**RE: 2206-227, 4603 89th Ave. SE  
Post Permit Revision**

This letter accompanies plans for a post-permit revision. The revision consists of moving the proposed ADU east to attach to the proposed main house and incorporating a swim-spa area west of the ADU. The new ADU location encroaches on the proposed detention pipe location.

TITLE: DRAINAGE PLAN
SHEET: C-2

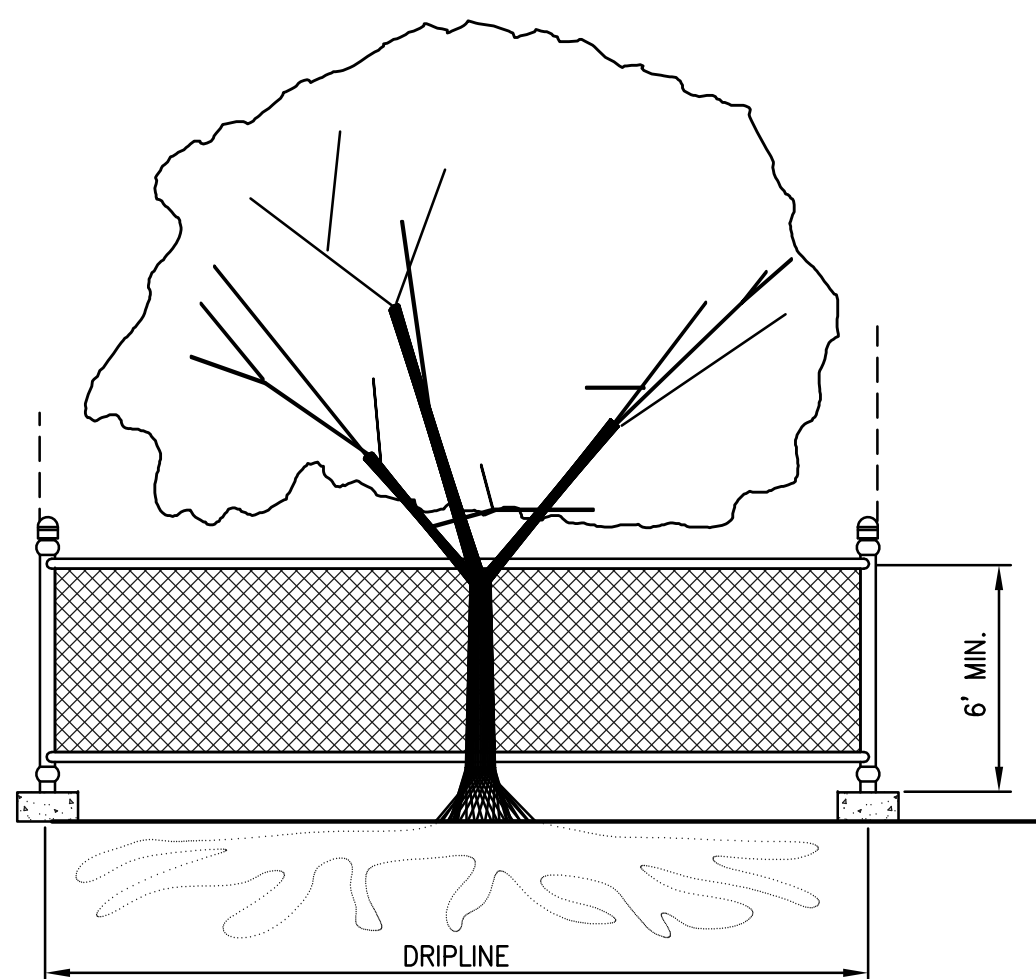
The new proposal is to reduce the footprint area of the detention pipe by increasing the diameter from 36 inches to 42 inches. The proposed building height has been reduced by 6 inches to facilitate this. The grades on the driveway outside the garage have been lifted 6 inches.

The proposed 42-inch diameter detention pipe was designed by matching rate control performance to that of a 48-inch diameter pipe designed per Table 1 of City's On-Site Detention Design Requirements document. The required 48-inch diameter pipe was input into a storm event model to determine required release rates. A summary of the performance data is attached. The proposed 42-inch diameter pipe has equivalent rate control performance to the 48-inch diameter pipe. Computer printouts are also attached.
